Your Ref: OWPC4970
Our Ref: R/15/15/PL 21-01-2015
Please ask for:
Mr D Easton

Proposed installation of 2 no. velux style windows to east and west roof elevations
1 Merton Avenue Rustington

Thank you for your internet representation made on 21st February 2015 which has been recorded as '**an objection**' with the comments as follows:

proposed side elevation (East)

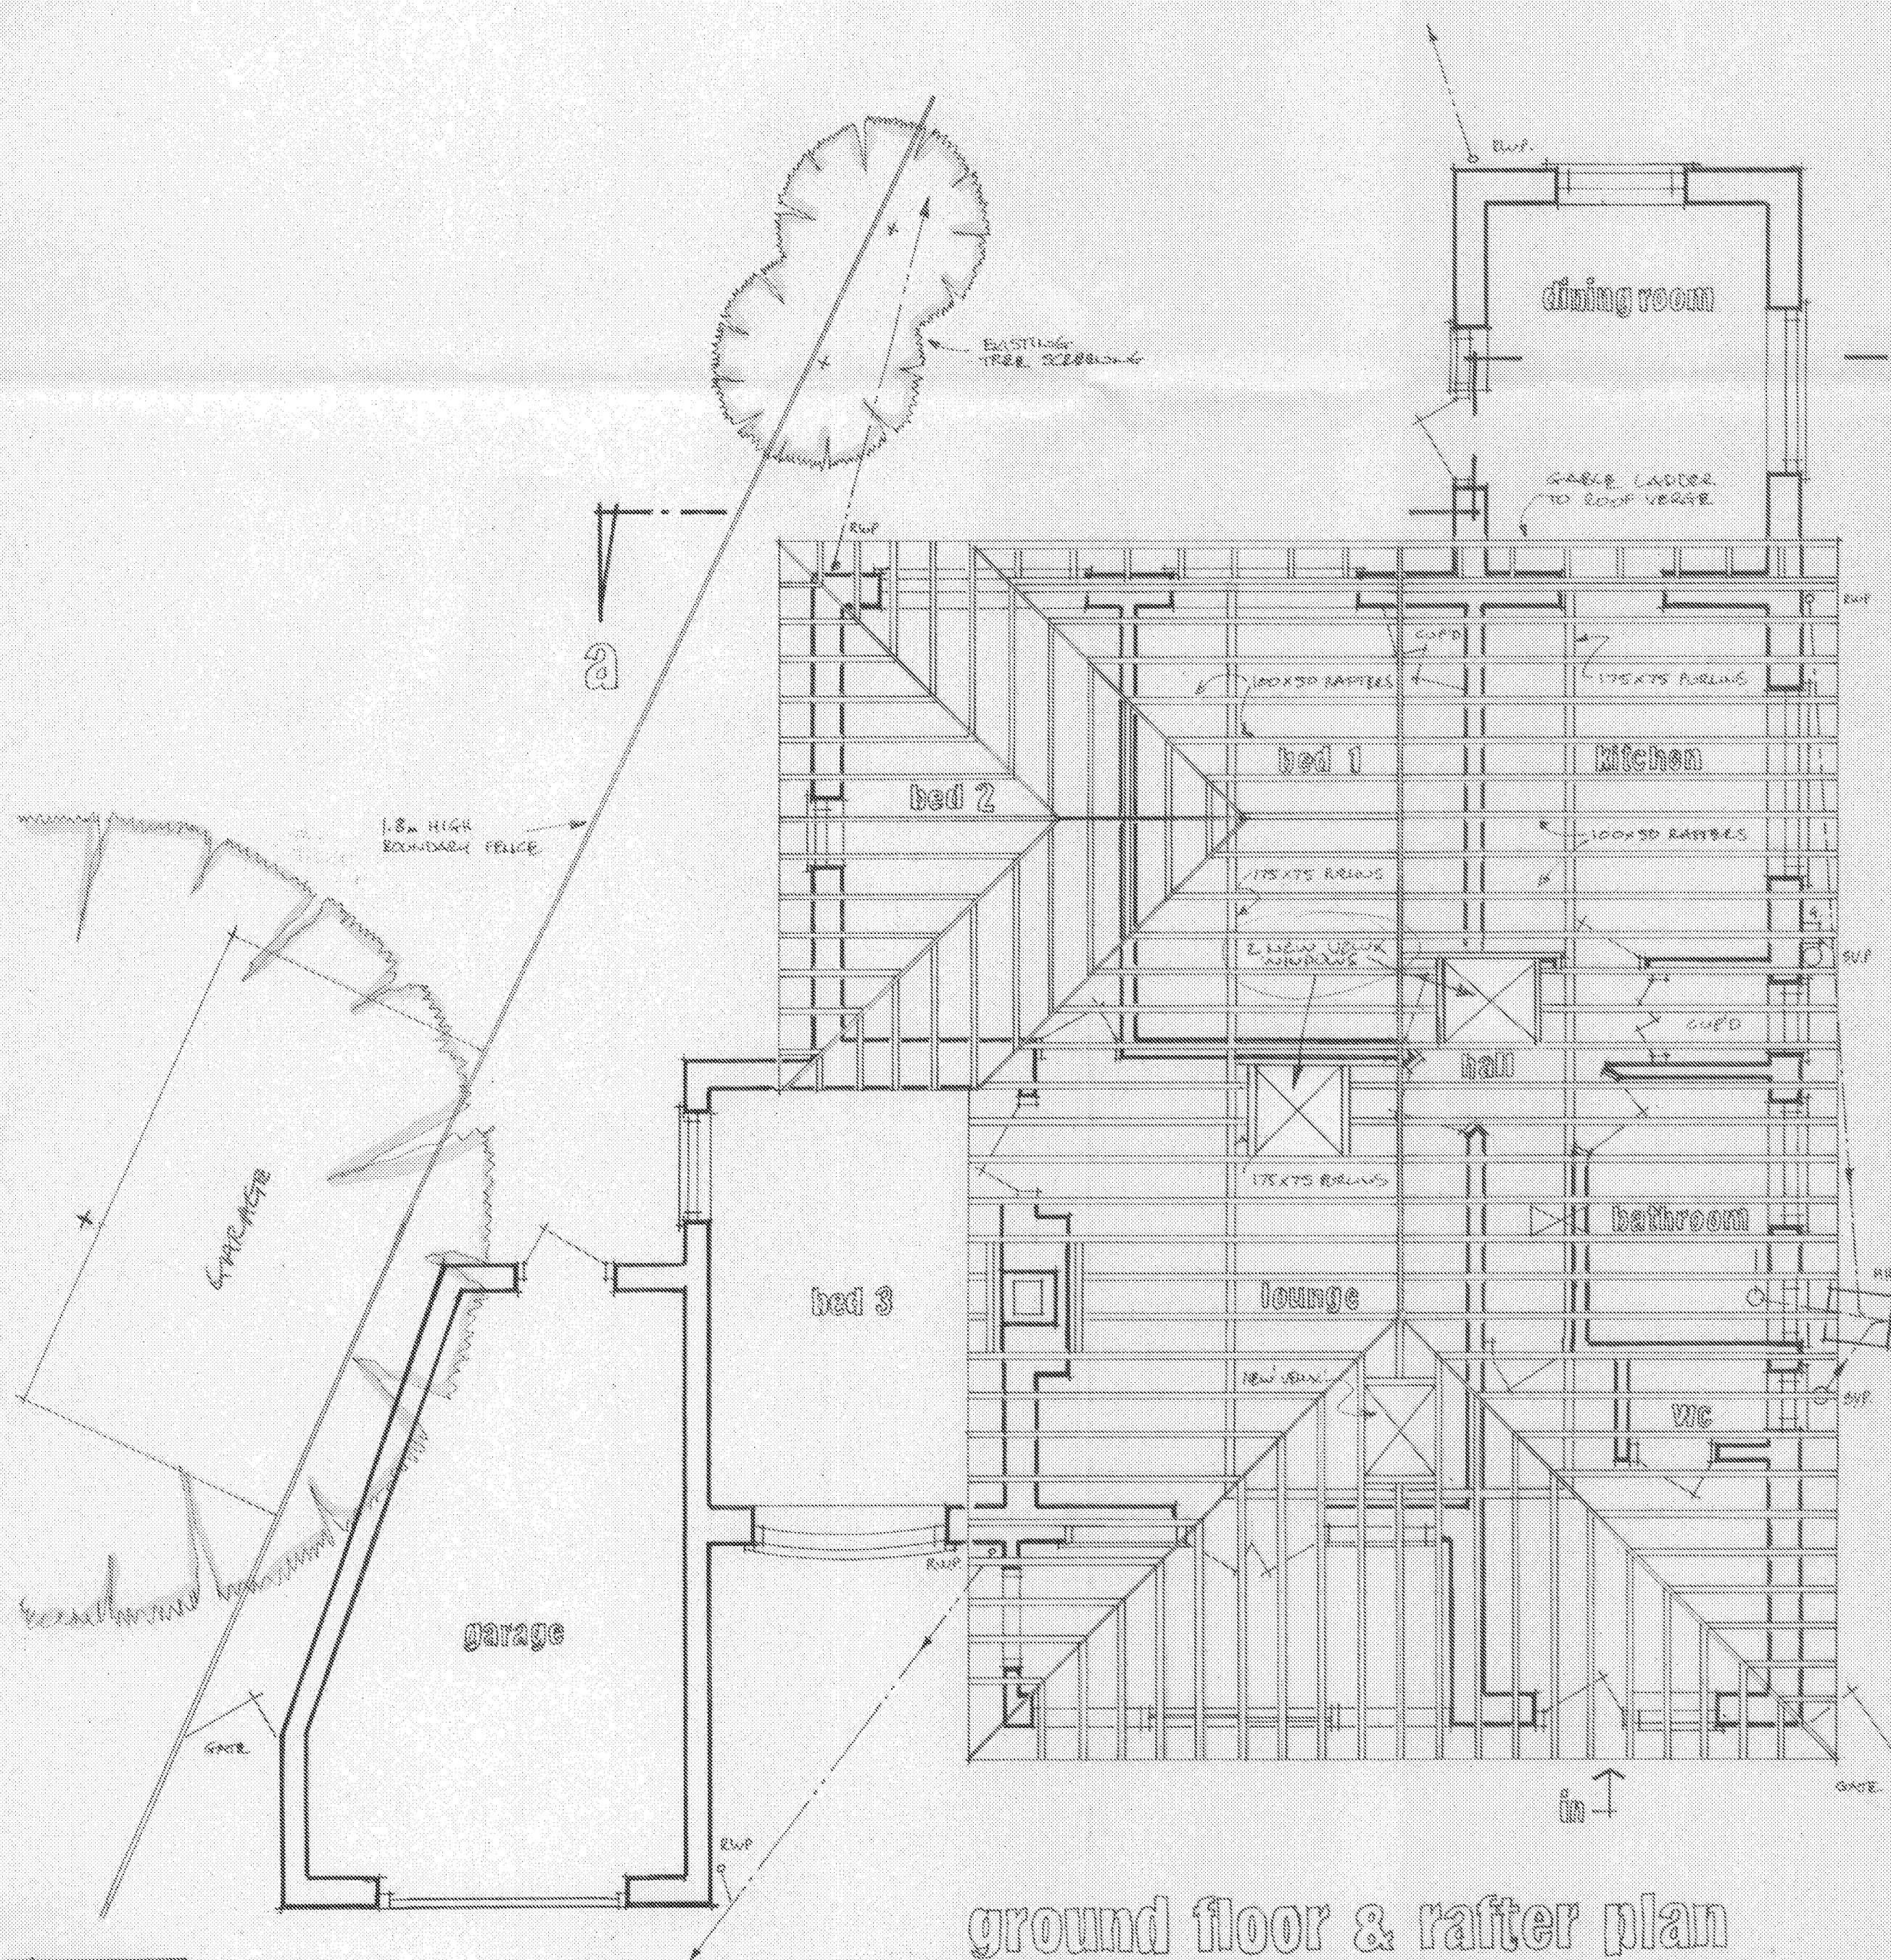
The installation of any window on the east side would have a direct line of sight into the windows of our home and down our garden, which I consider to be an infringement of our privacy rights. Their property is only a few feet away from ours: this is unacceptably invasive and intrusive.

There is no similar specific drawing to elaborate the impact on our property. The drawings provided incorrectly suggest that there is a long row of trees and hedges starting right next to the back of our bungalow down the entire length of our garden along the border joining 1 Merton Avenue to provide screening from this proposed development. This is not the case.

(WEST) SIDE ELEVATION - PROPOSED

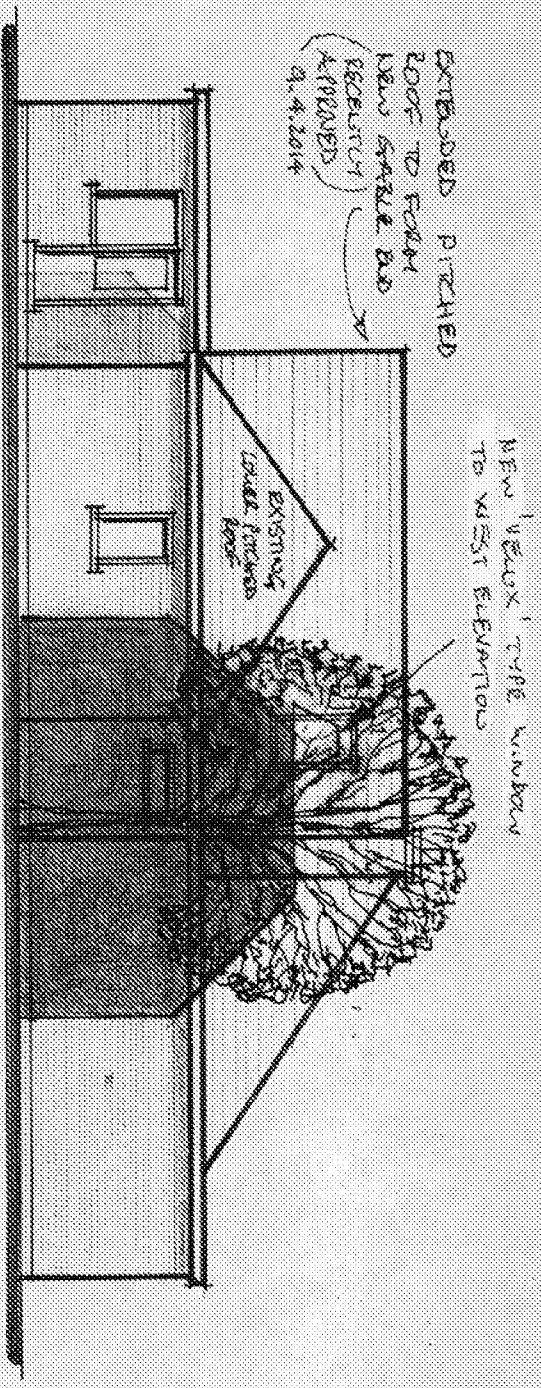
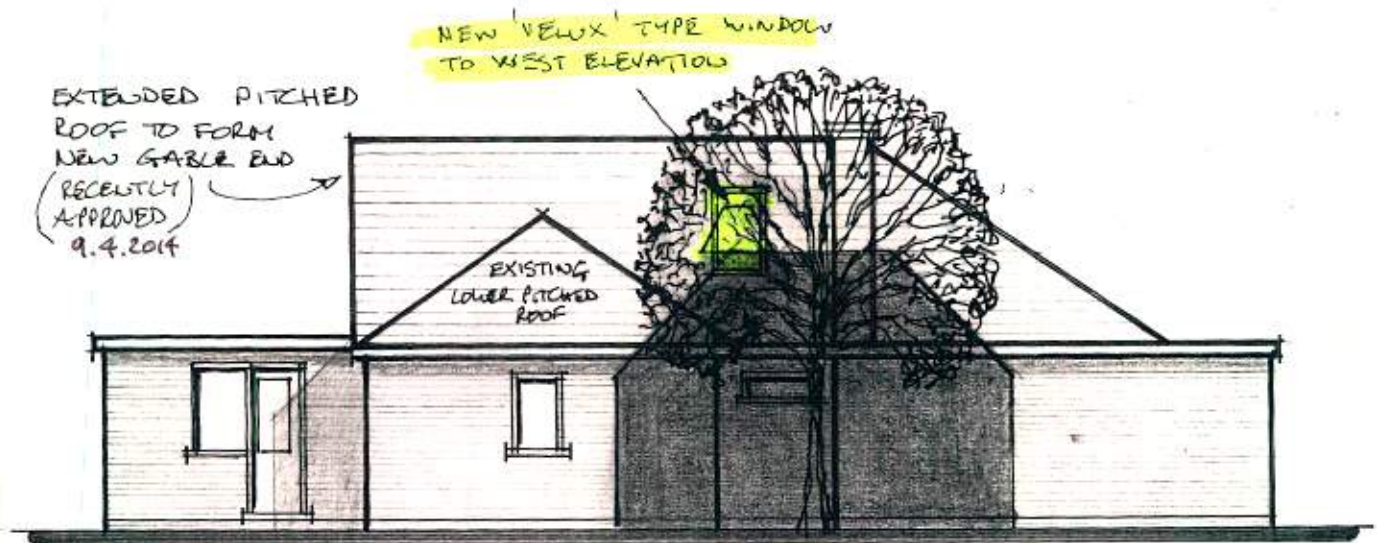
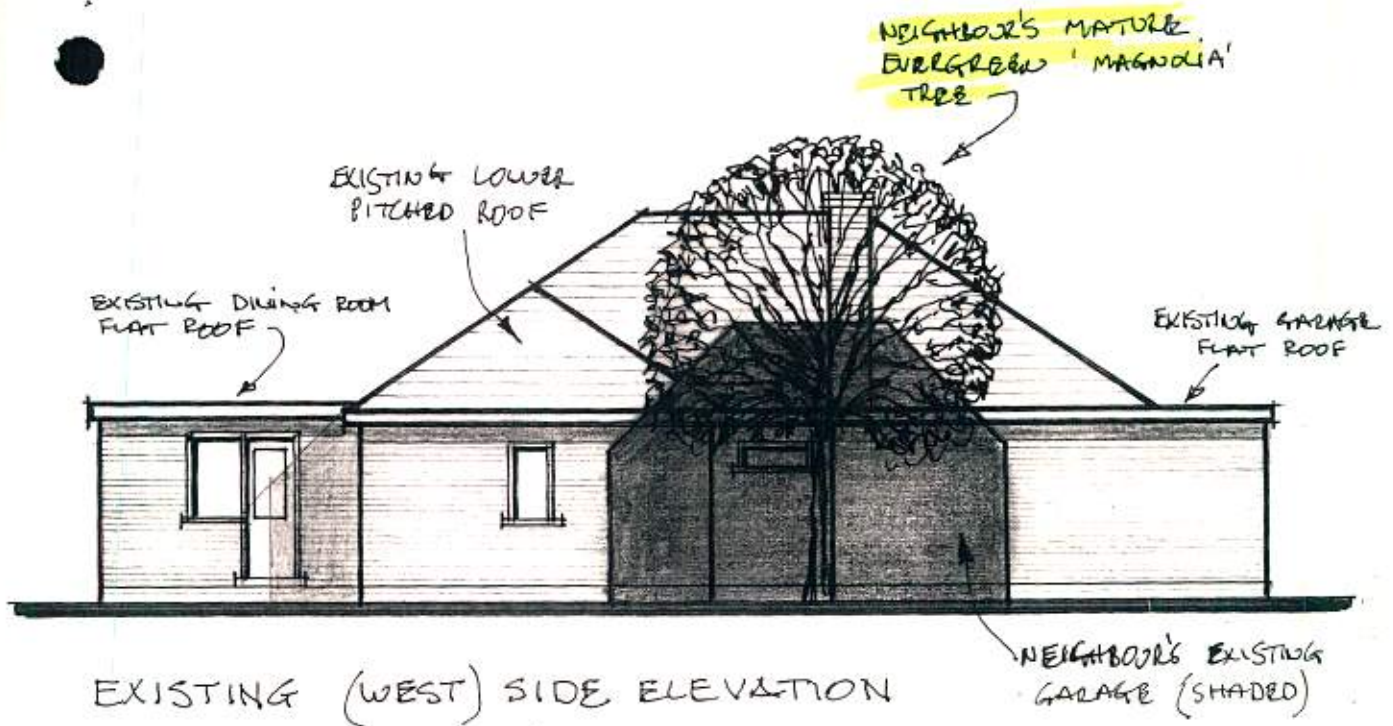
The plan shows the view from the west side alleging that the properties to this side will be offered some form of screening by trees, lower pitched roof, and a garage. No such "protection" is afforded to our property.
